CITY OF MERCER ISLAND

Pre-Application Meeting (PRE20-045)

Site Location:	4001 WMW		
Lot Size:	31,500sf	Zoning:	R-15 (Single Family)
Brief Project Description:	Subdivide 1 lot into 2 lots.	Documents Provided:	Discussion points, plan set, pre-app form, project narrative, and tree inventory
Applicant Information:			
<small>Name:</small>	Mark Wischman	<small>Email:</small>	mark@wischmanmgt.com
		<small>Phone:</small>	206-909-5559
Second Pre-application Meeting Required:	Not Applicable	NA

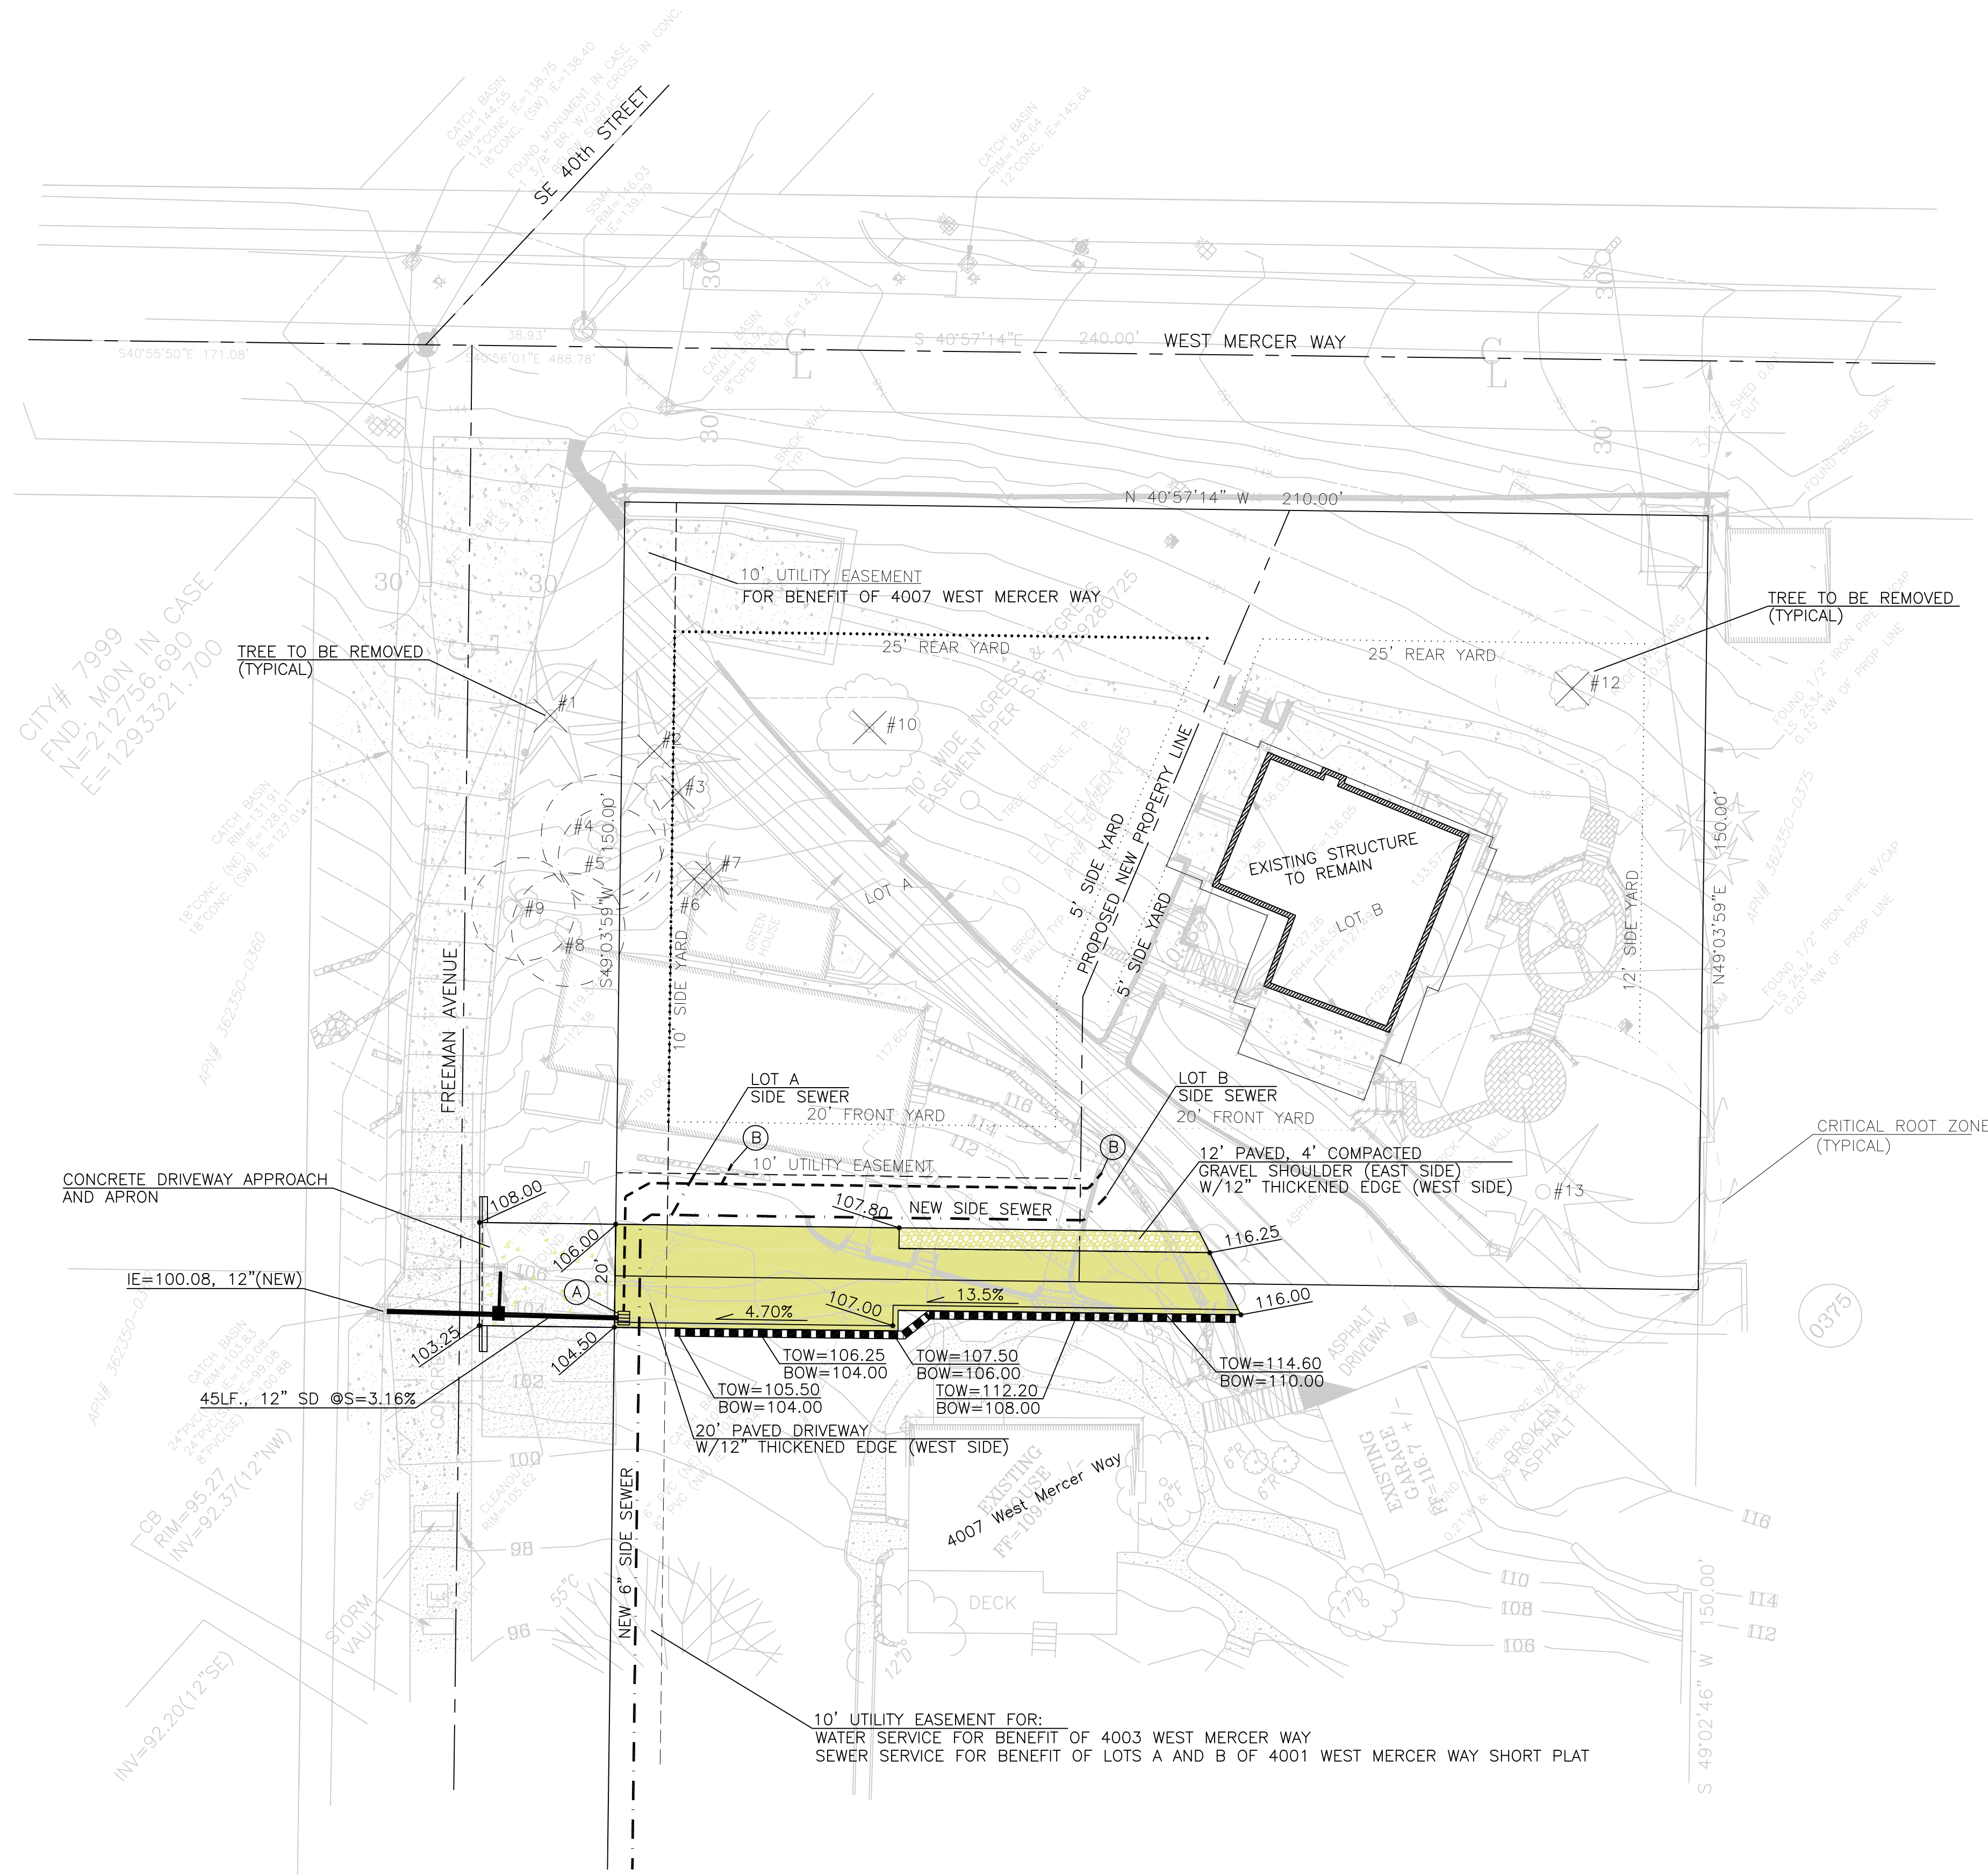
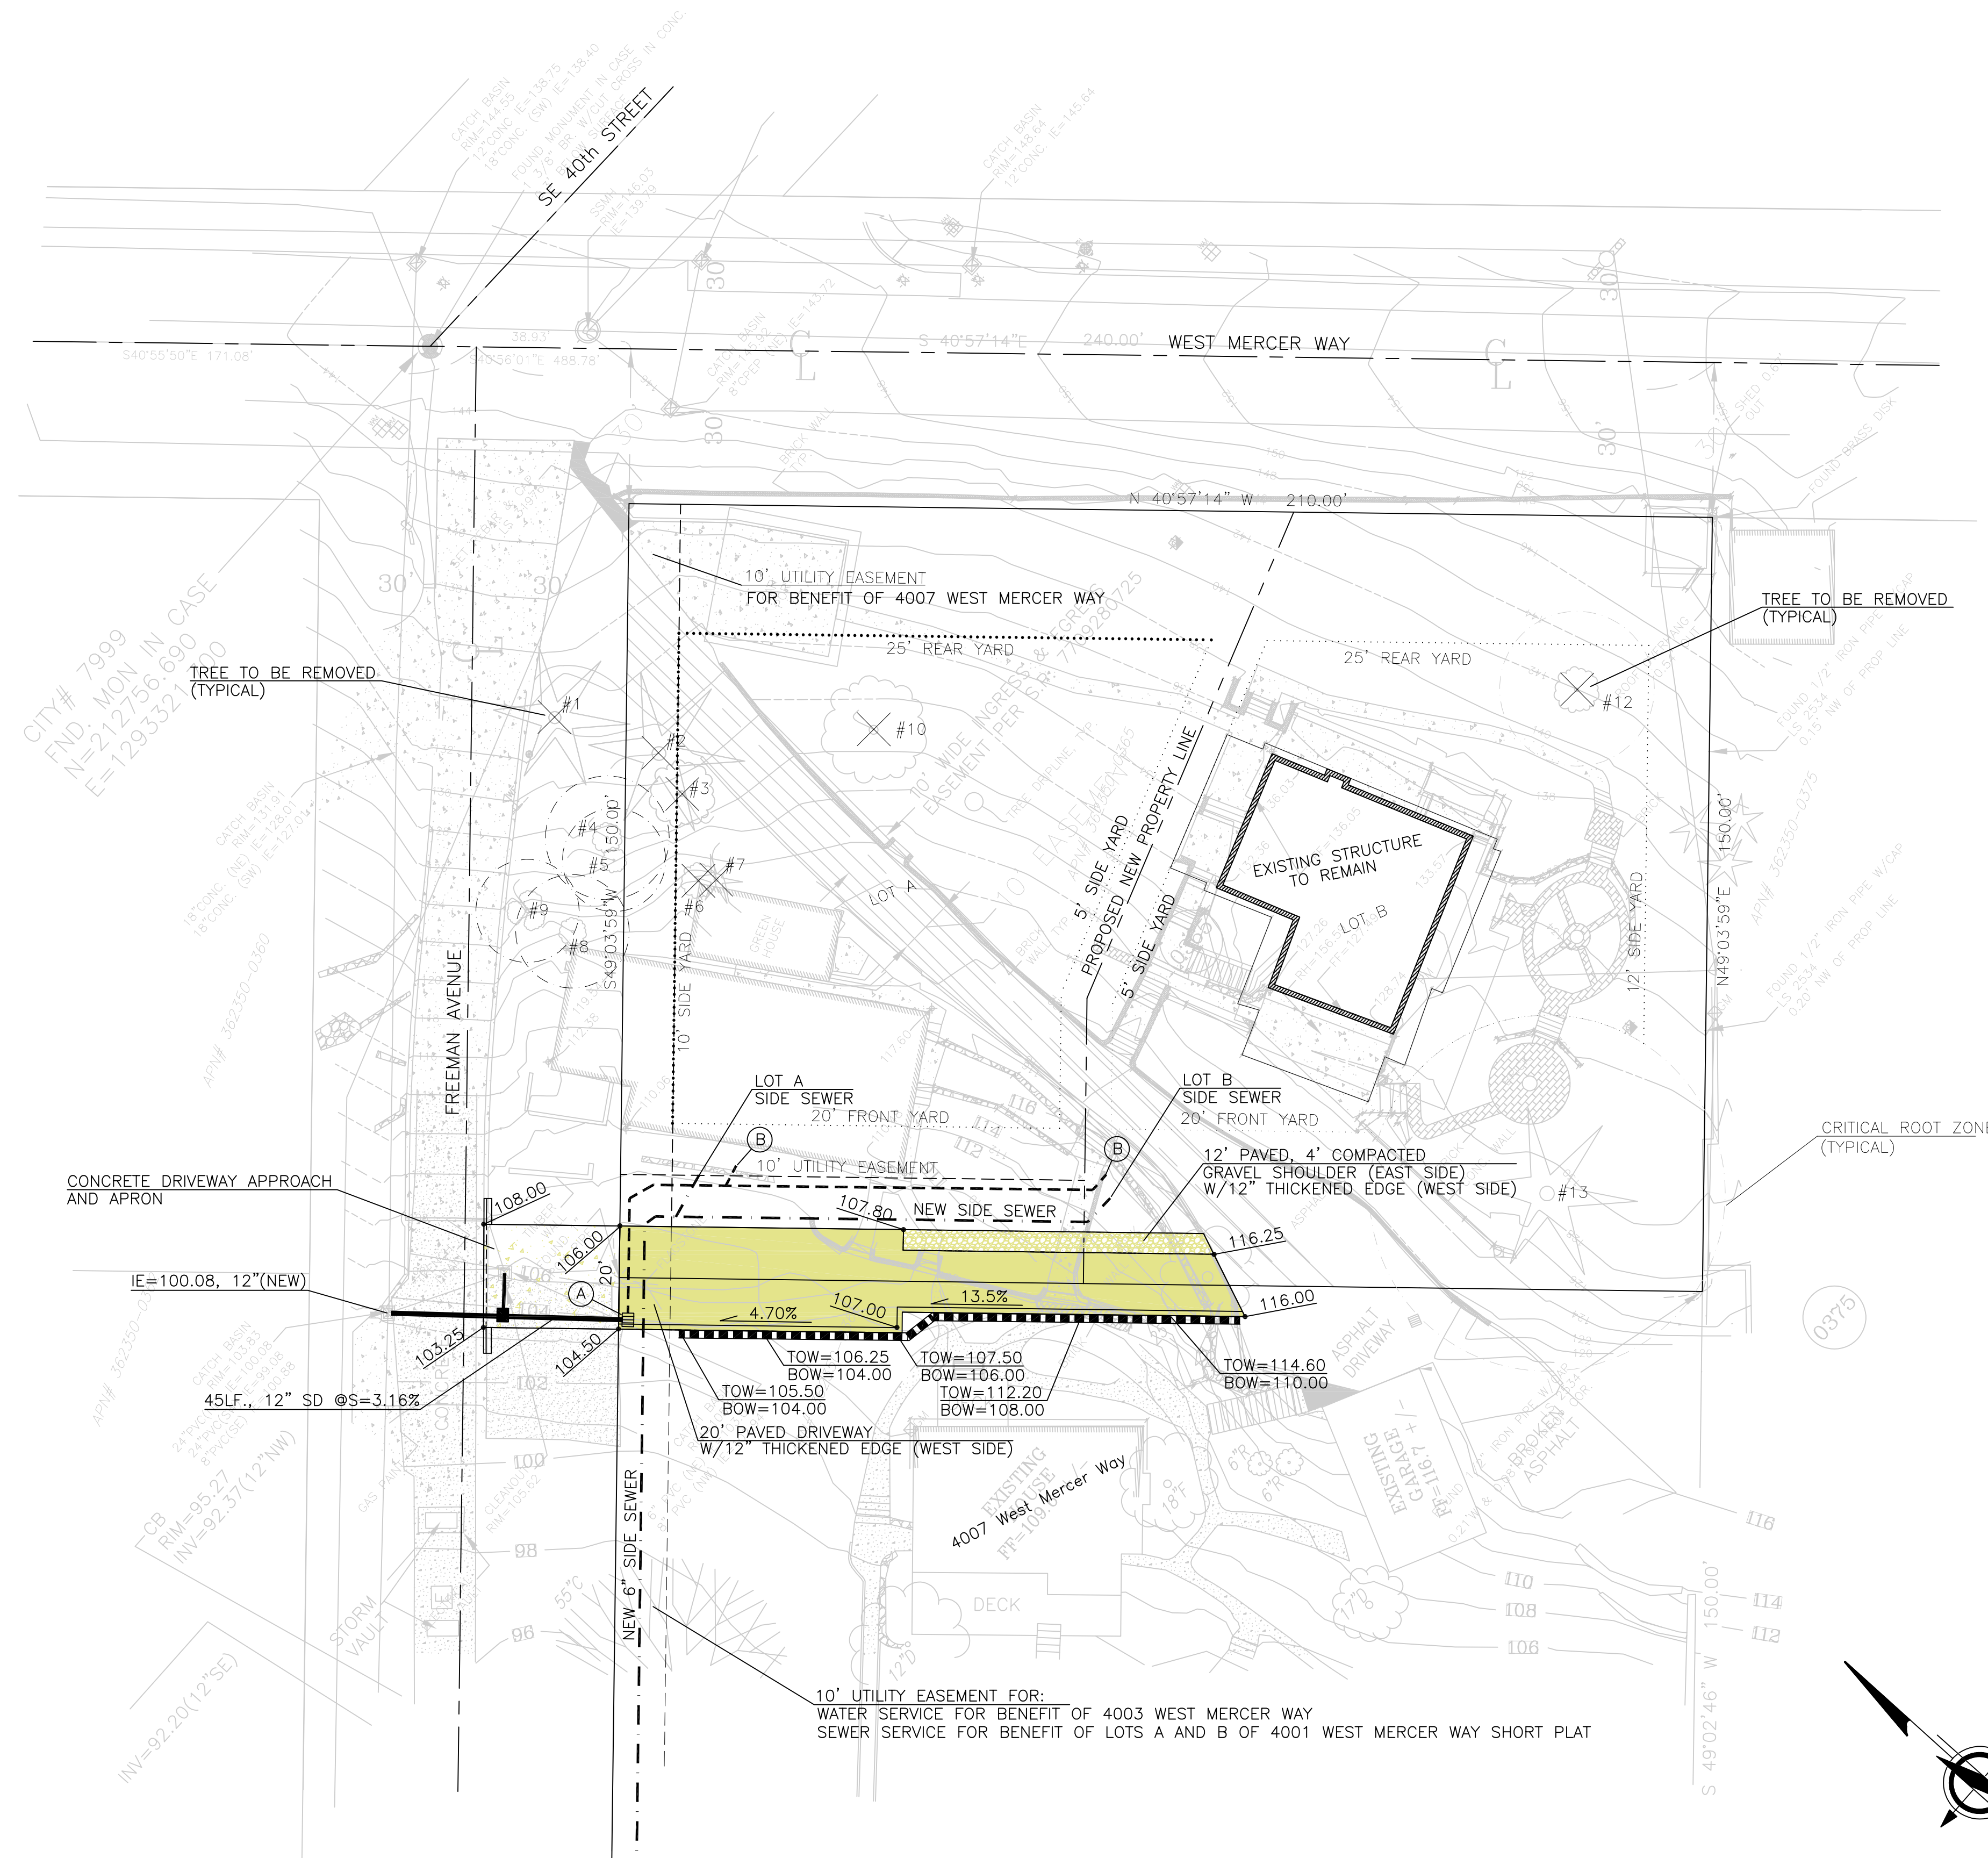
1. Utilities:
 - a. Sewer service to "cabin" (Lot B) is from 6" sewer from 4003 and 4007 West Mercer Way properties. Can Lot A serve from same side sewer?
 - b. Freeman Avenue storm drainage has direct discharge into Lake Washington, would detention be required?

1. A 6" side sewer line can be shared to a maximum 6 single family houses. The new side sewer from both new lots can connect to the 6" side sewer with easements, and the 6" side sewer will need to be verified in a good conditions.
2. The drainage design will need to follow the city drainage code, if none of LID BMPs is feasible for the site, then you can direct connect to the storm drainage system on Freeman Ave. without a detention system.
